REQUEST

Current Zoning: R-5 (single family residential)
Proposed Zoning: UR-3 CD (urban residential, conditional)

Approximately 0.52 acres located at 1118 Parkwood Avenue, adjacent to Pegram Street in the Belmont neighborhood.

SUMMARY OF PETITION

**REZONING PLAN 2019-156**

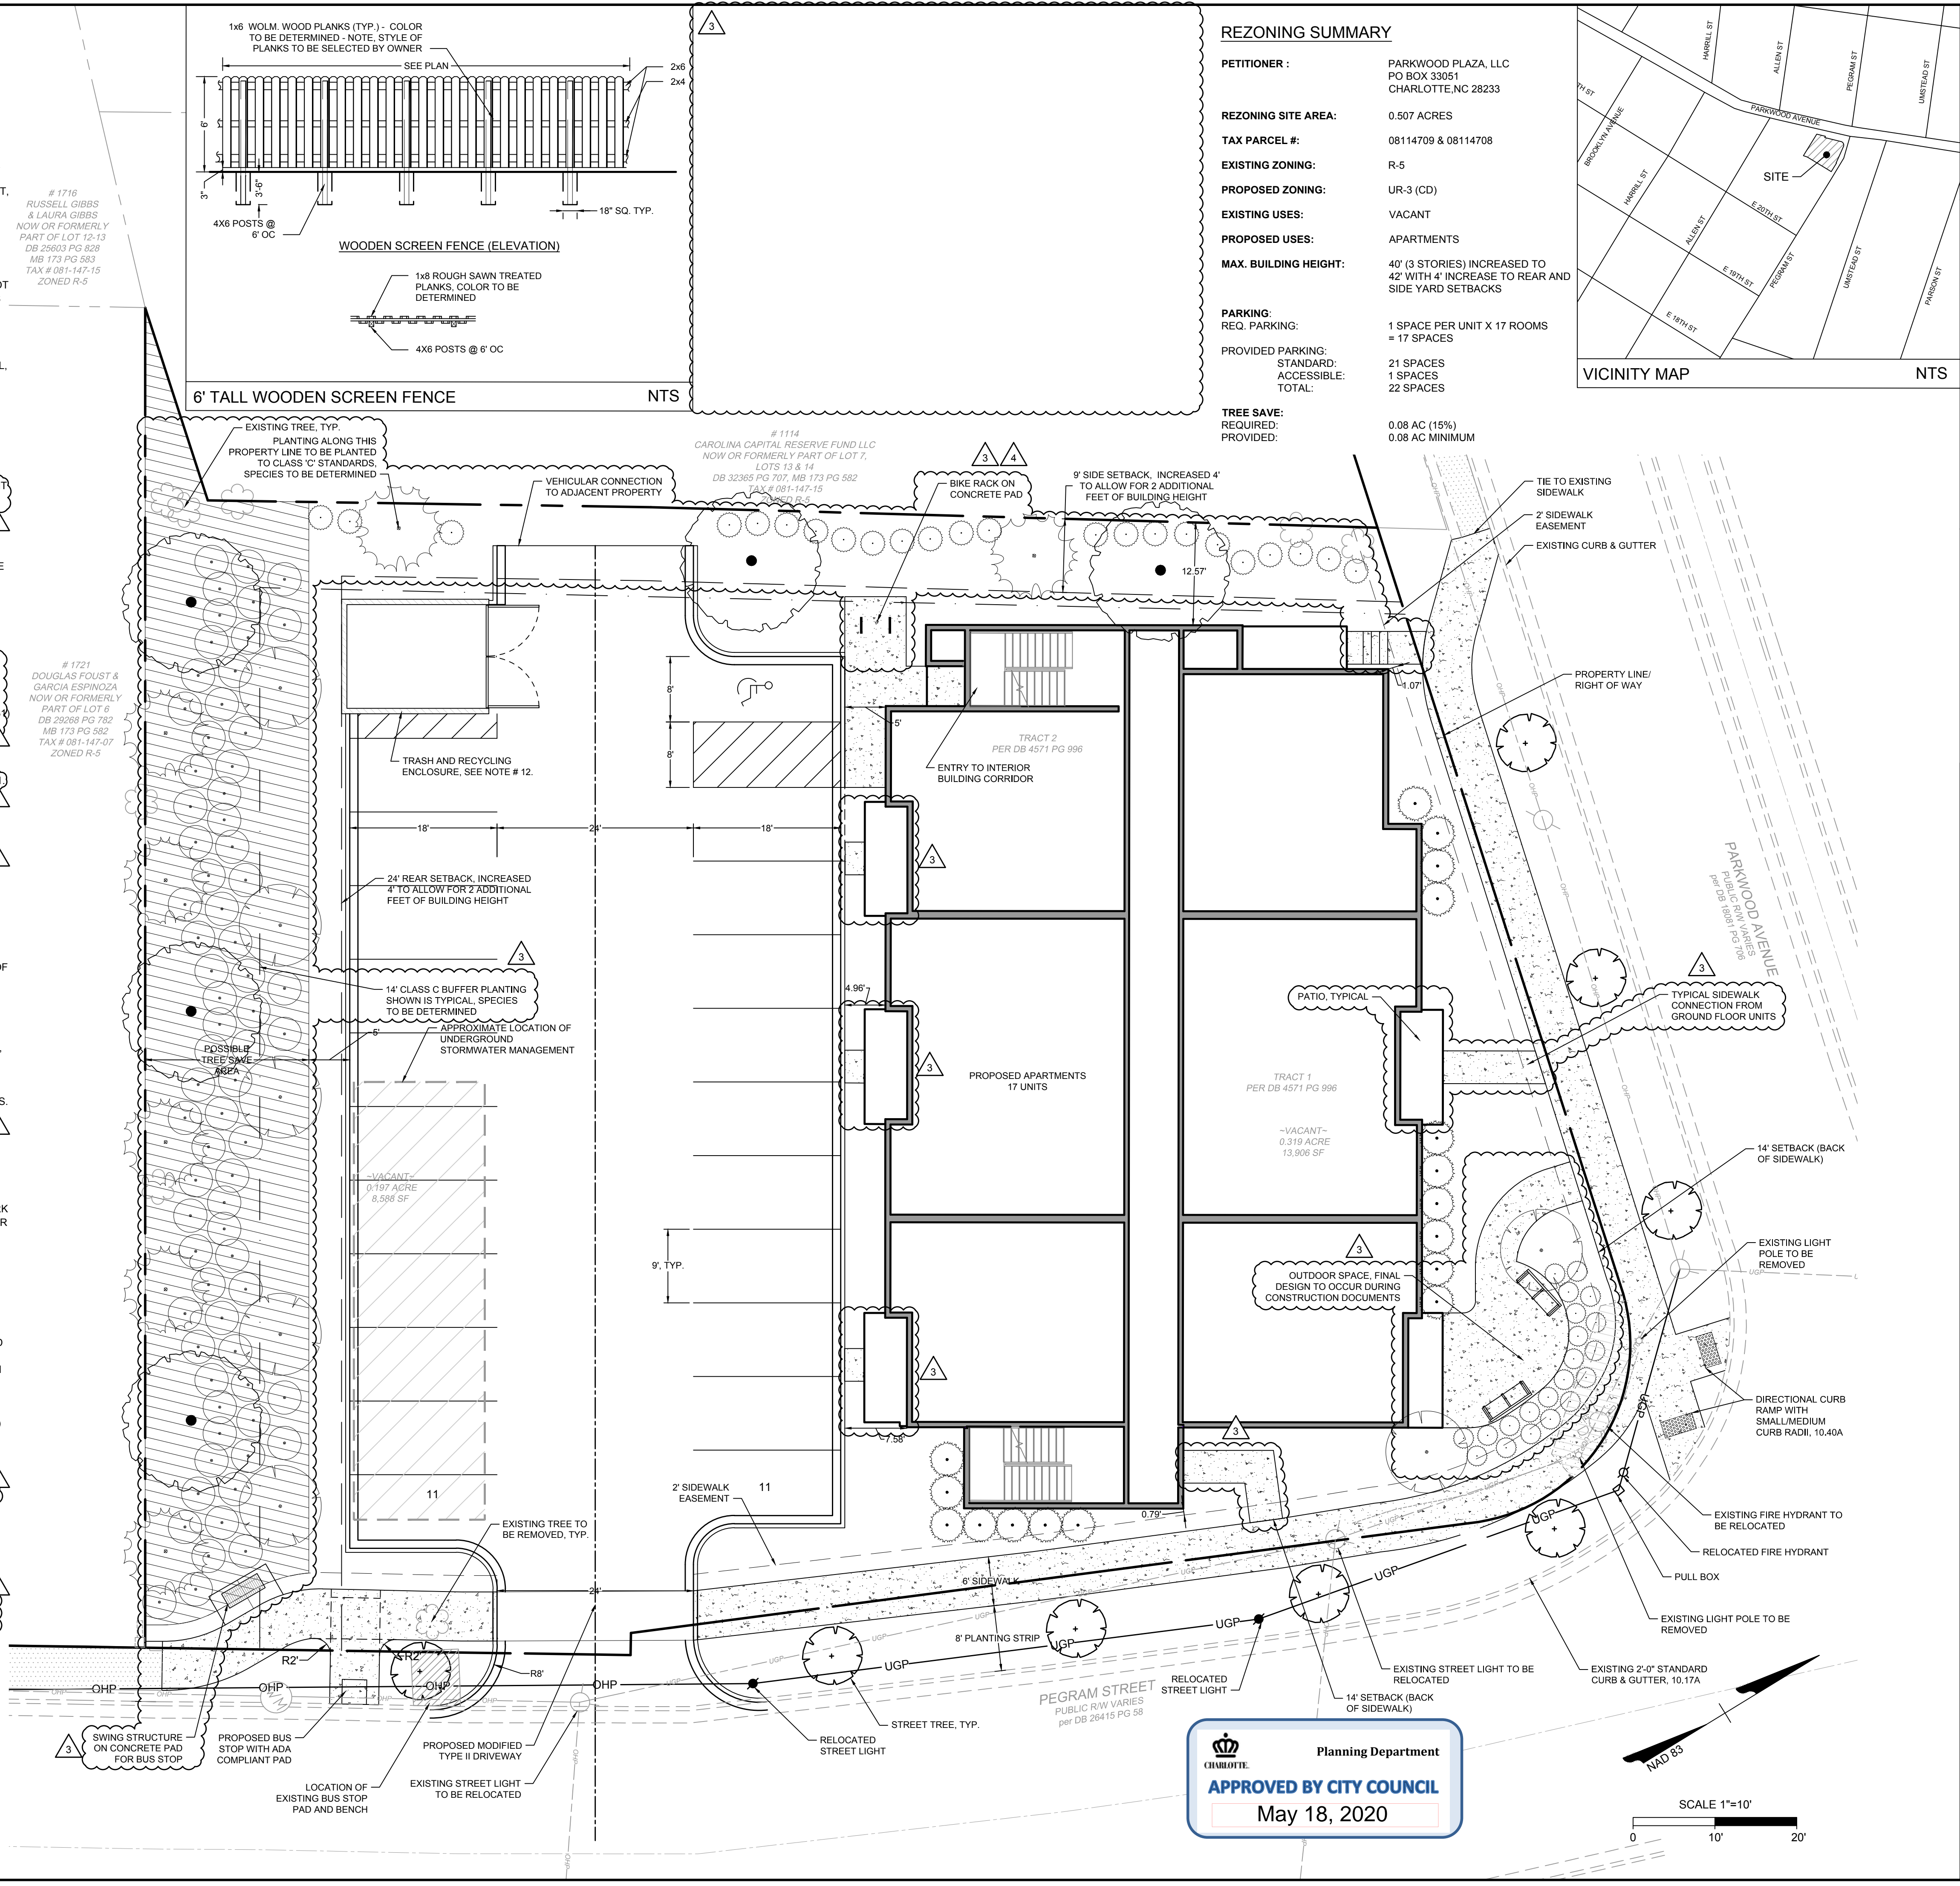
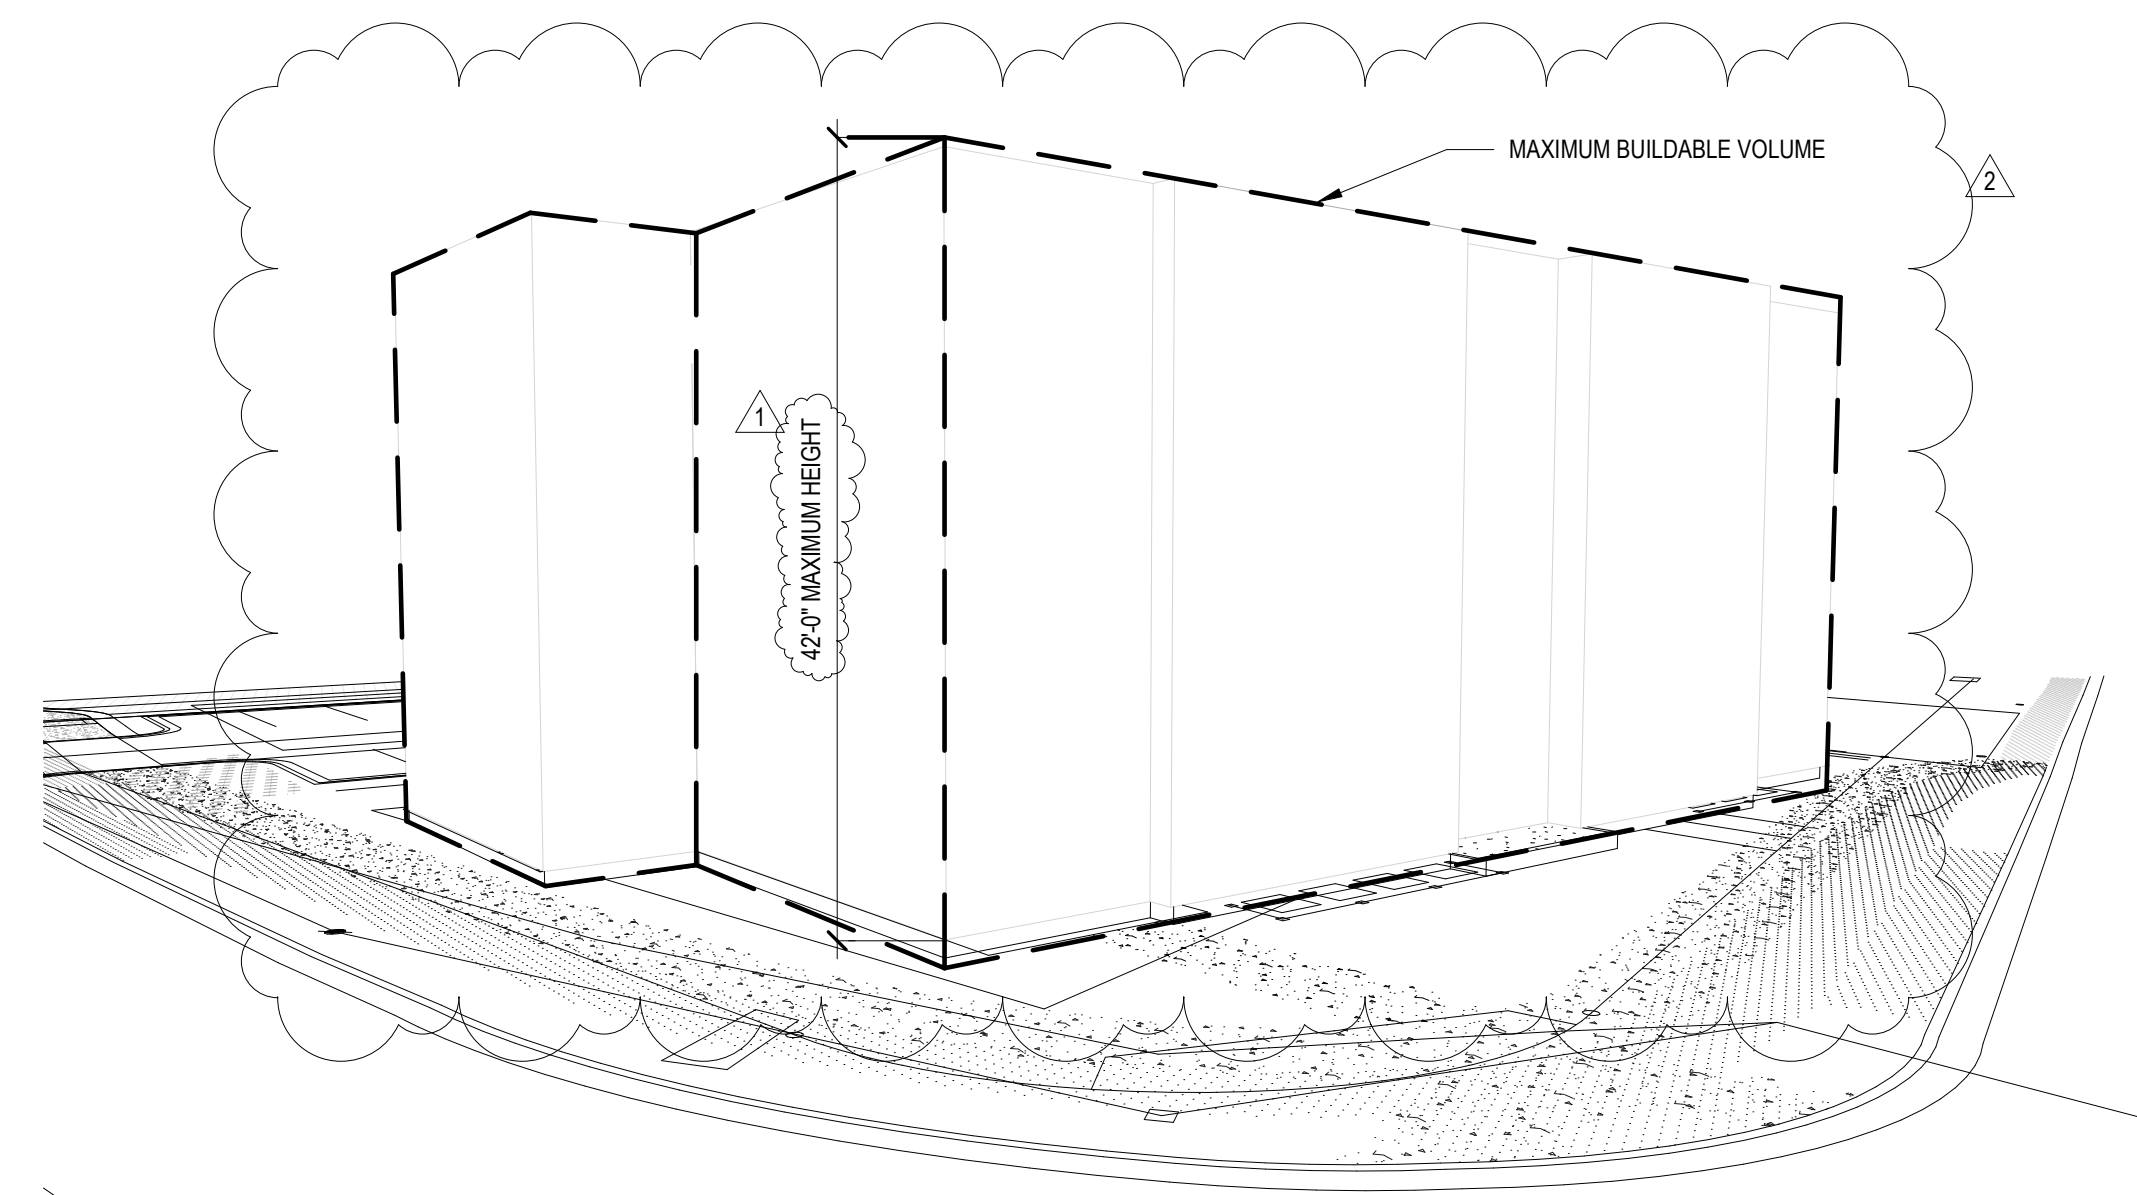
1. Commit to installing the inter-parcel access point shown on site plan revision dated 1/15/2020.
2. The proposed structure should be replaced with single family homes or a structure which does not exceed the recommended residential density for the subject property.

3. Revise conditional note(s) to commit to construct two directional ramps at the intersection of Parkwood Avenue and Pegram Street, per the *Parkwood (N. Davidson - The Plaza) Improvements* construction plans. Please refer to these plans within the rezoning site plan and conditional note(s). The Parkwood (N. Davidson – The Plaza) plans are available upon request.
